Colorado Springs, CO
Planning and Development

Final Report - Corrections Required
Application No. DEPN-22-0222

Description : A new 53 unit apartment complex
Address : 0 8th ST Colorado Springs CO 80905
Record Type : Development Plans
Document Filename : Development Plan Set

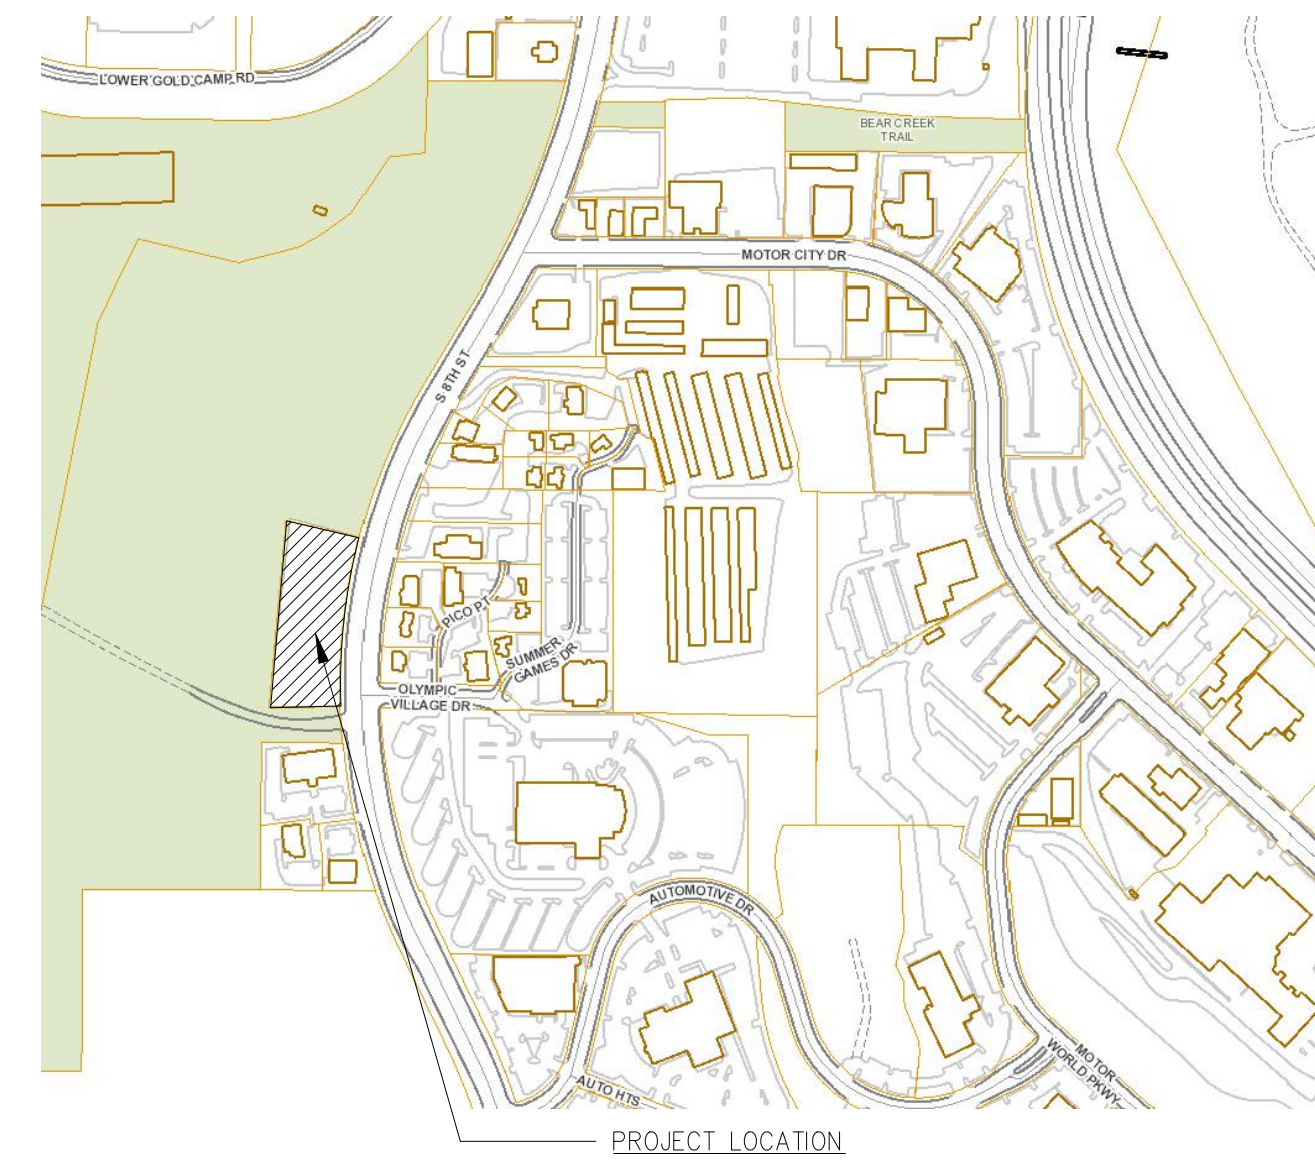
Comment ID	Page Reference	Author : Department	Review Comments
34	1	Hao Vo : City Engineering - SWENT	FIRM panel number should read 08041C0729G.
35	1	Hao Vo : City Engineering - SWENT	Include the flood zone in the Floodplain Note on the cover sheet (e.g. Zone X).
36	1	Hao Vo : City Engineering - SWENT	Please show and label major drainageways in the vicinity map.
37	1	Hao Vo : City Engineering - SWENT	Include a scale for the vicinity map.
38	1	Hao Vo : City Engineering - SWENT	Title the Development Plan as shown on the Plat.
40	6	Hao Vo : City Engineering - SWENT	This is labeled as a grass lined swale on the Grading Plans, but these plans show rock. Please clarify.
19	1	Joel Dagnillo : City Engineering Dev Review	Geological hazard report will be sent to CGS (Colorado Geological Survey) for review. After they have a chance to comment, the City will determine if report will be approved or needs further review. Thank you.

1 FIRE ACCESS PLAN
1" = 20"

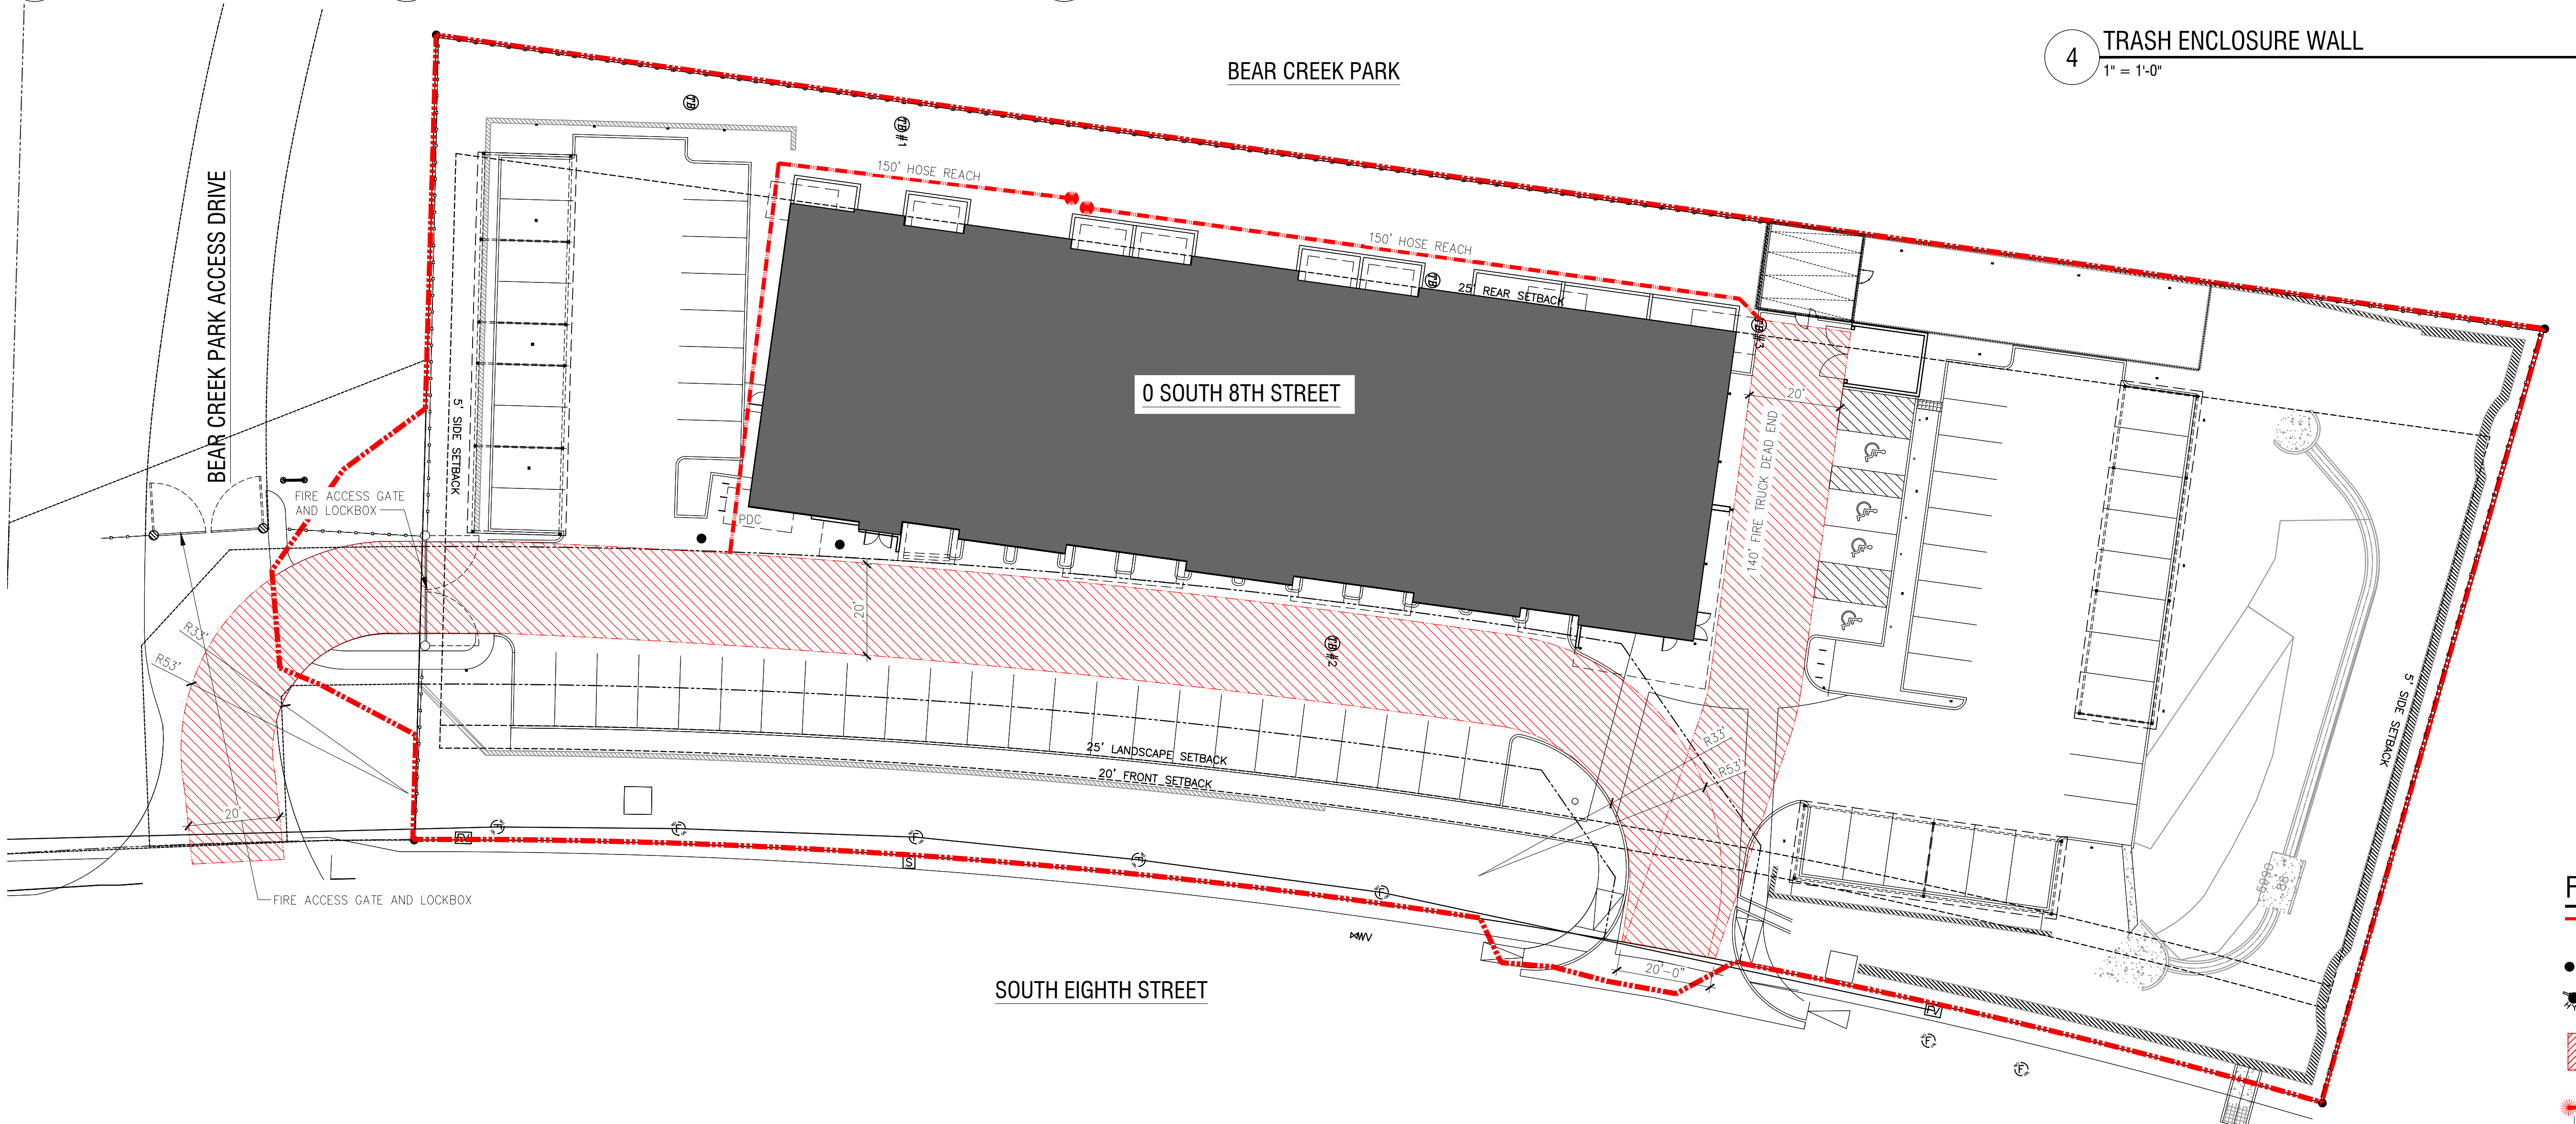
16	4	Joel Dagnillo : City Engineering Dev Review	Show ped ramps behind crossspan, approximately in these locations
17	4	Joel Dagnillo : City Engineering Dev Review	Label as CITY STD. D-21
18	4	Joel Dagnillo : City Engineering Dev Review	Show curb chase cover extending to property line
2	1	Daniel Gould : Planning	Update sheets 6 thru 8 to read "Final Landscape Plan and Details"
21	1	Cory Sharp : Planning	As previously requested and not addressed, update the legal description language from the final subdivision plat. Leave the to be platted as Vue De La Parc at the end of the description.
22	1	Cory Sharp : Planning	Please remove the description of the access easement. The easement needs to be created by a separate recorded document and the information of the recorded document add to the plan.
23	1	Cory Sharp : Planning	Please update the City File No. DEPN-22-022 on all sheets.
24	2	Cory Sharp : Planning	As previously requested and not addressed, add the "bearings" on the exterior boundary labels.

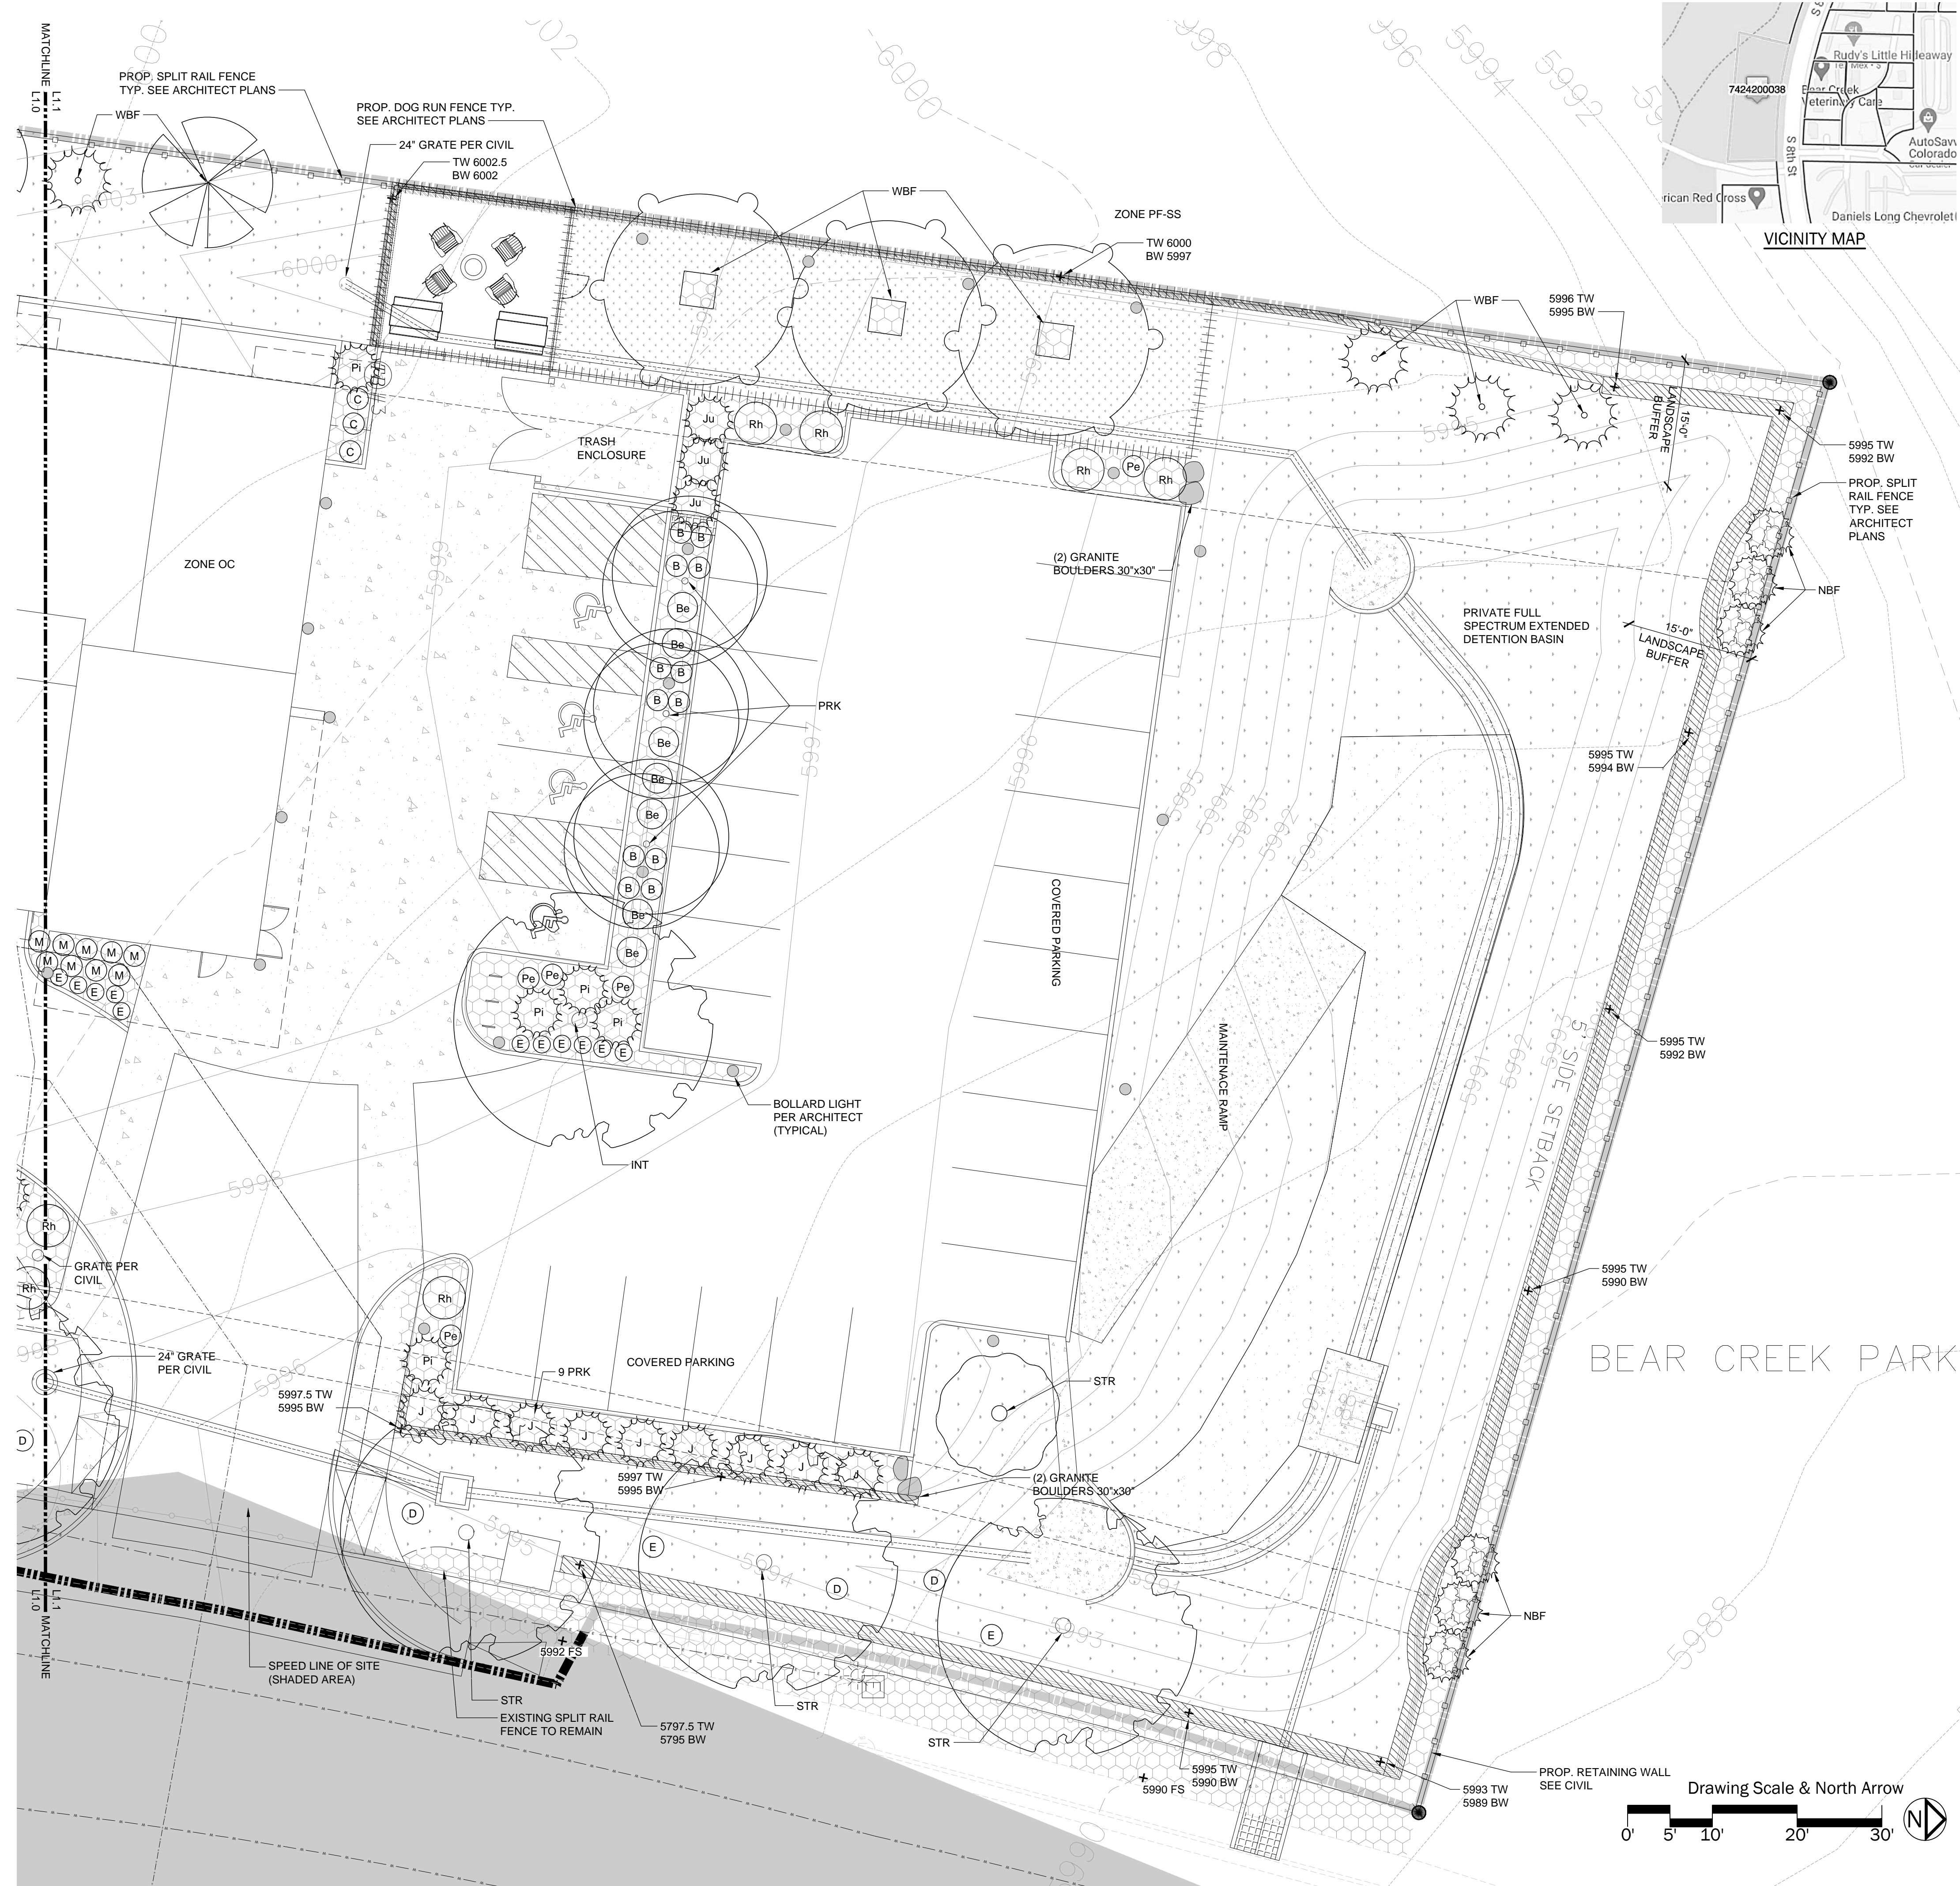
Comment ID	Page Reference	Author : Department	Review Comments
13	6	Daniel Gould : Planning	add the following after the zoning "Bear Creak Park"
15	6	Daniel Gould : Planning	If any site trash enclosures are planned, show and label on the plans and provide landscaping (fastigiated form) screening around the sides of the proposed trash enclosure (where we have space - 7.4.323.C.5 and H and FLP Check list #30).
7	7	Daniel Gould : Planning	Confirm the total amount of provided trees, staff is getting 65, revise the plans as needed.
8	7	Daniel Gould : Planning	Confirm the total amount of provided shrubs for the site, per the Site Calculation Charts, a total of 152 are needed but only 122 are provided. Revise the plans and plant schedule as needed.
3	8	Daniel Gould : Planning	Add the following notes to this section: "AN IRRIGATION PLAN SHALL BE SUBMITTED AND REVIEWED CONCURRENT WITH BUILDING PERMIT SUBMITTAL AND APPROVED PRIOR TO ISSUANCE OF A BUILDING PERMIT AND BEFORE ANY IRRIGATION CONSTRUCTION."
